From: Eamonn Roberts
Sent: 24 April 2012 14:44
To: Graeme Thorpe
Subject: Planning Application 320120194P Co op Barrow

PROPOSED PLAN LAYOUT

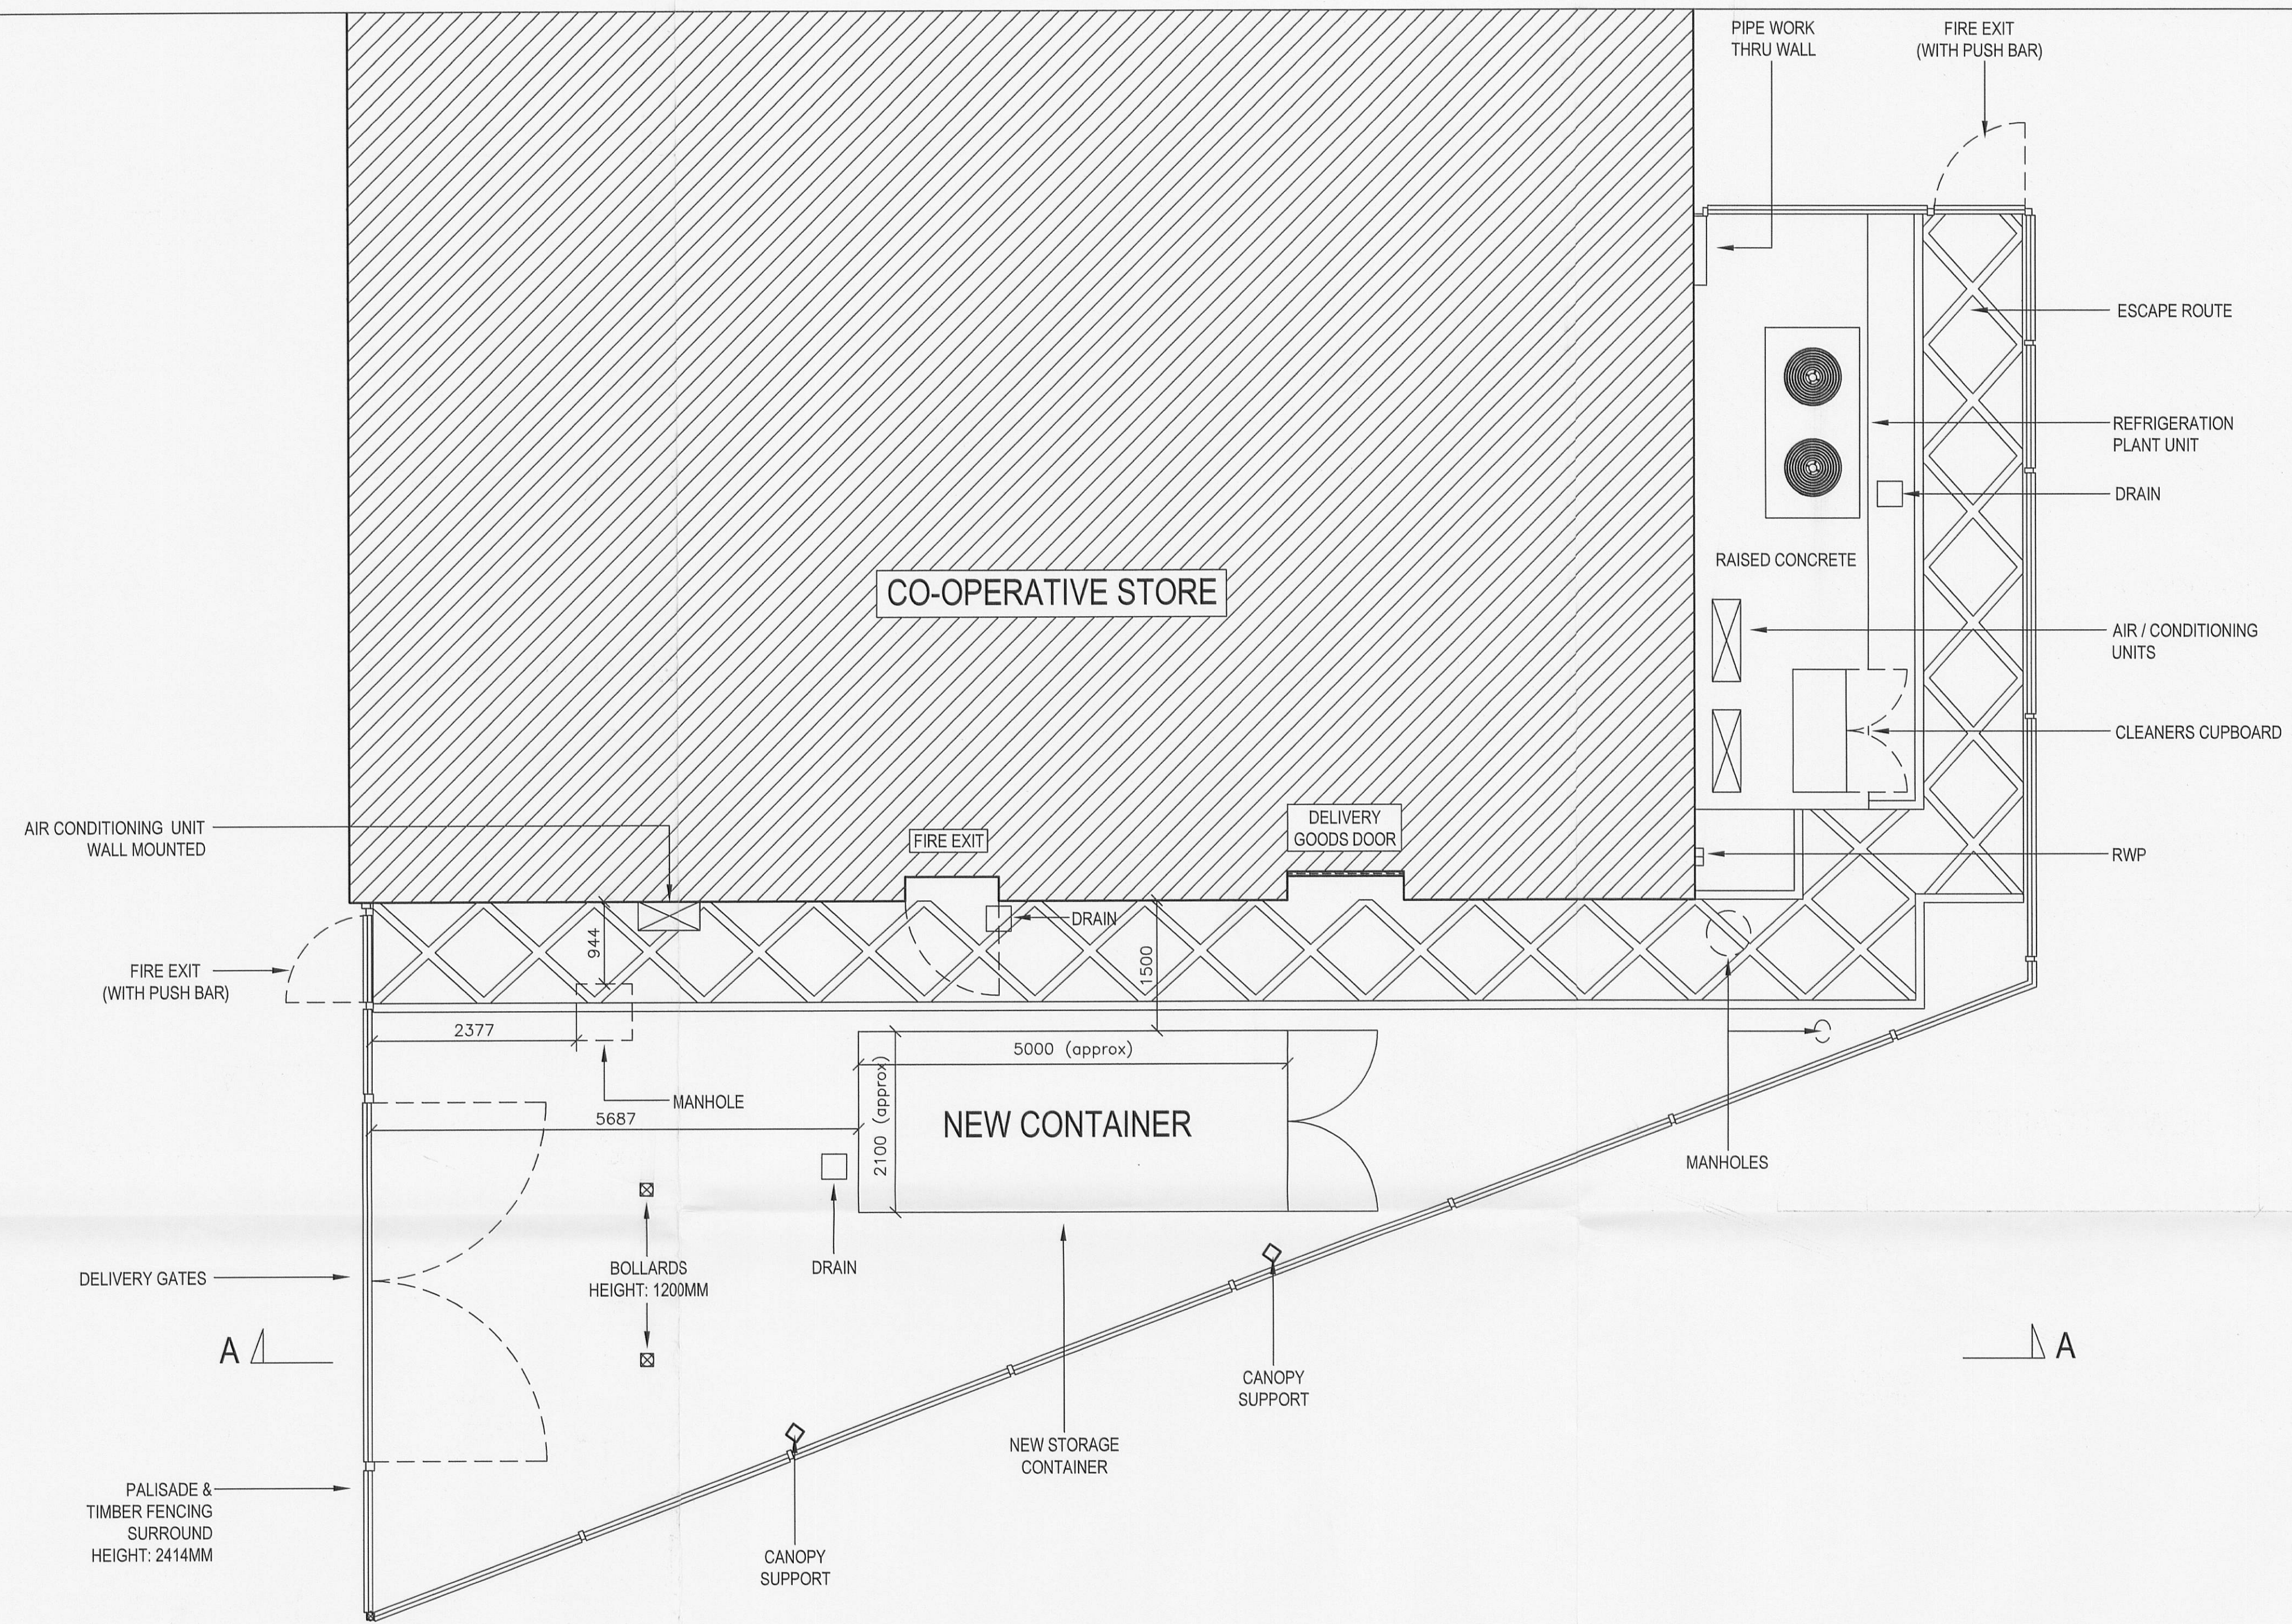
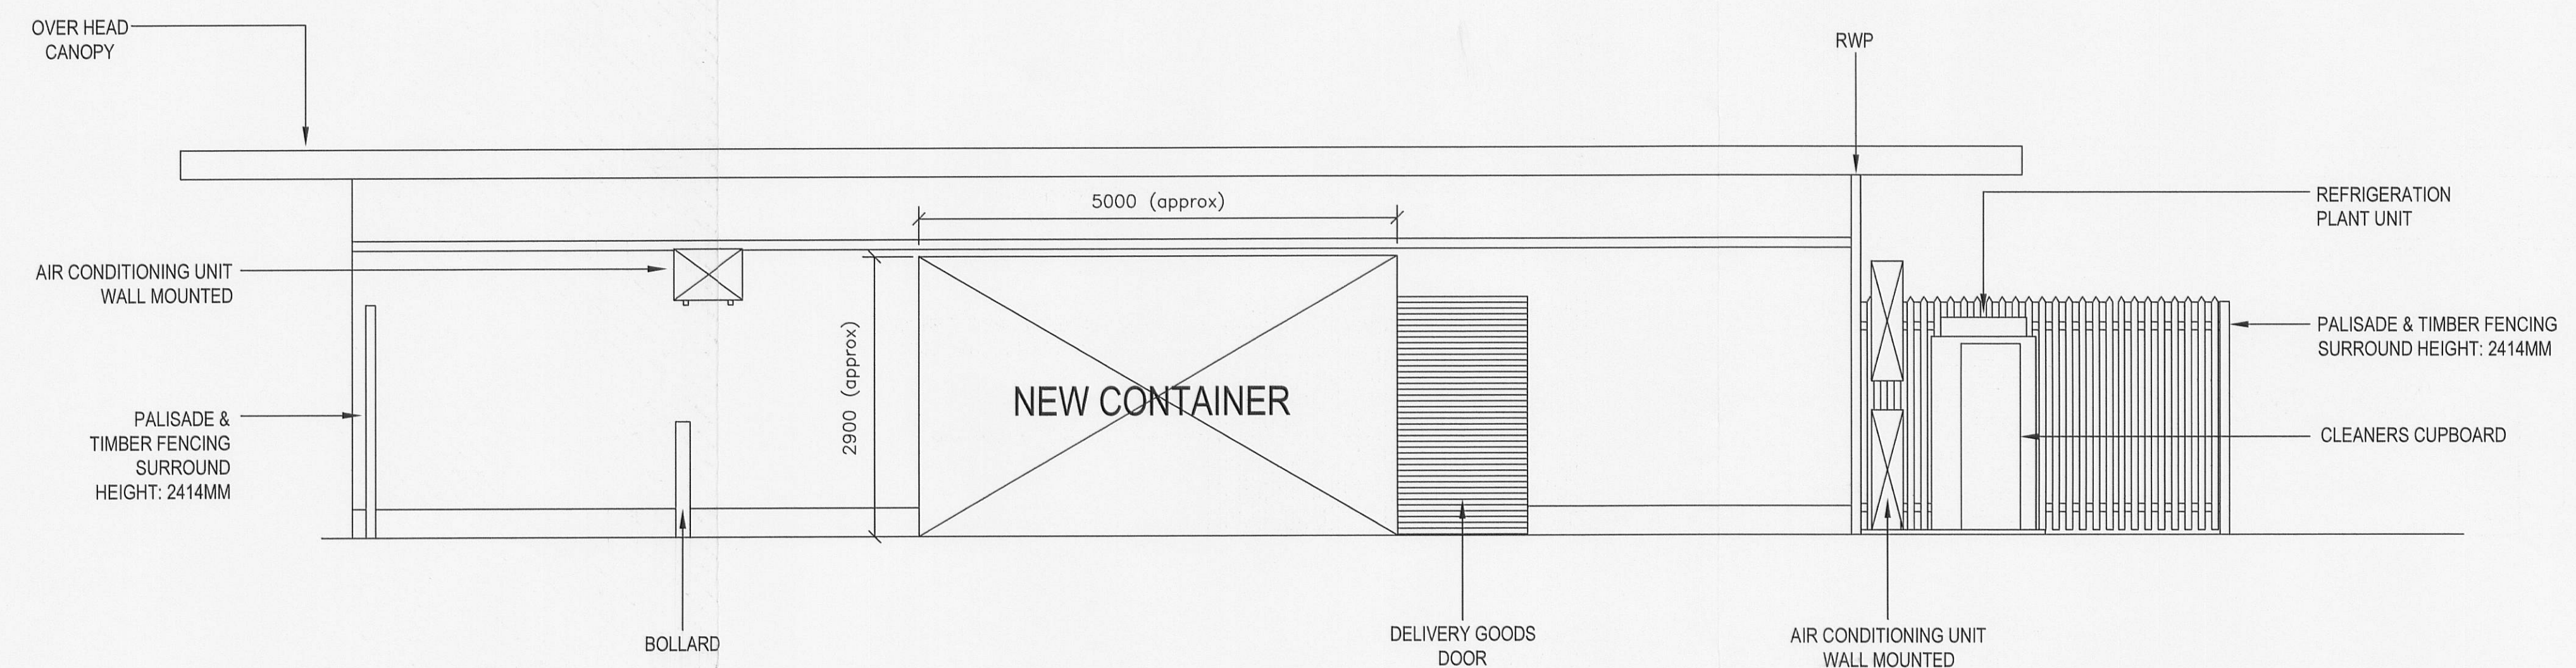
I would have no objections to this "trolley store". However, if it was to be used as a food store, as I suspect it will be, it would need to comply with the requirements of Regulation (EC) 852/2004 which would require it to be pest proof, and have adequate ventilation and lighting.
